From: [Holly Duncan](#)
To: [Jeff Watson](#)
Subject: RE: BL-10-00044 Ivin
Date: Friday, December 10, 2010 12:34:33 PM

From: Jeff Watson
Sent: Friday, December 03, 2010 9:20 AM
To: Christina Wollman; Brenda Larsen; Jan Ollivier; Holly Duncan
Subject: BL-10-00044 Ivin

[BL-10-00044 Ivin](#)

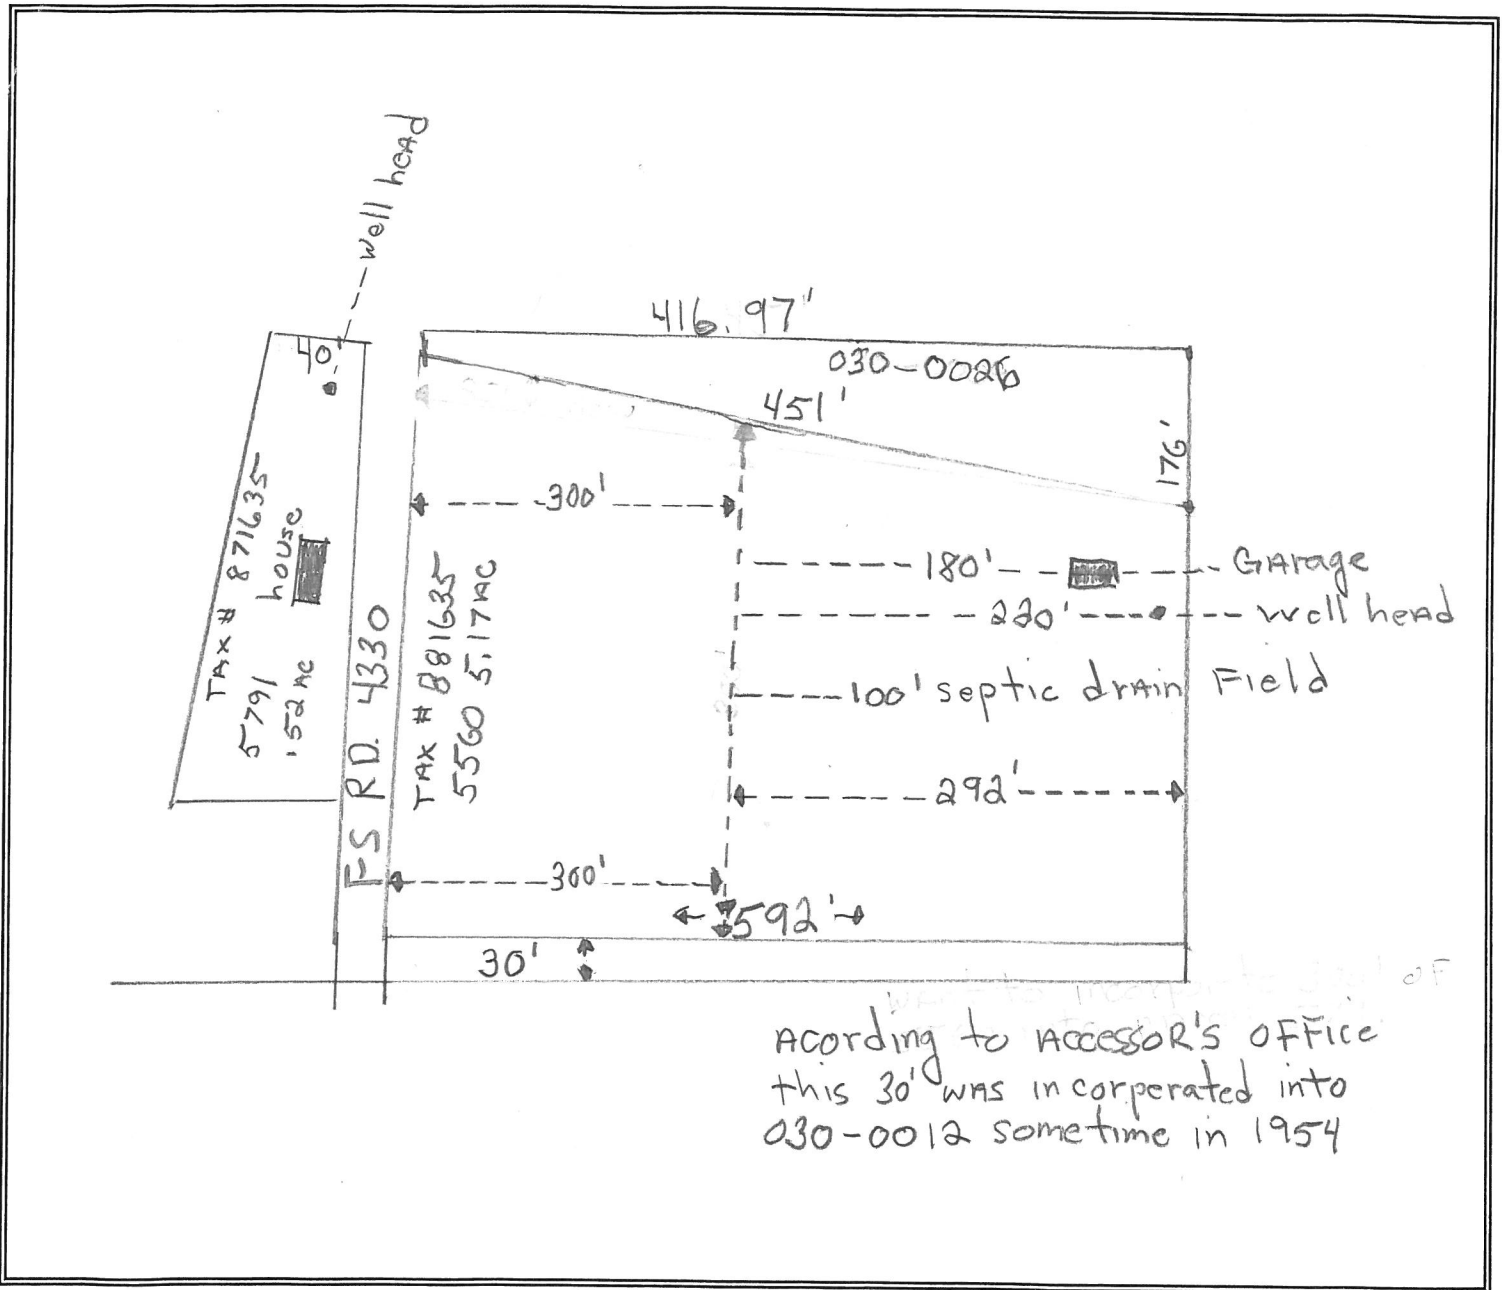
Looking at the site plan and the parcel configuration it appears to me that the well is forty feet from an adjoining property in different ownership (Henshaw) which is not part of the requested BLA. I don't think we are in a position to do anything about that within the context of this application but...? The other parcel's well head although no measurement is given, appears close to the east boundary, but again, not impacted by the requested alteration. Let me know what if anything can or should be done...

I have some questions on this one. It appears that the well(s) may not be 50 feet from the property lines in this one.

OK, I'll trust your judgement.
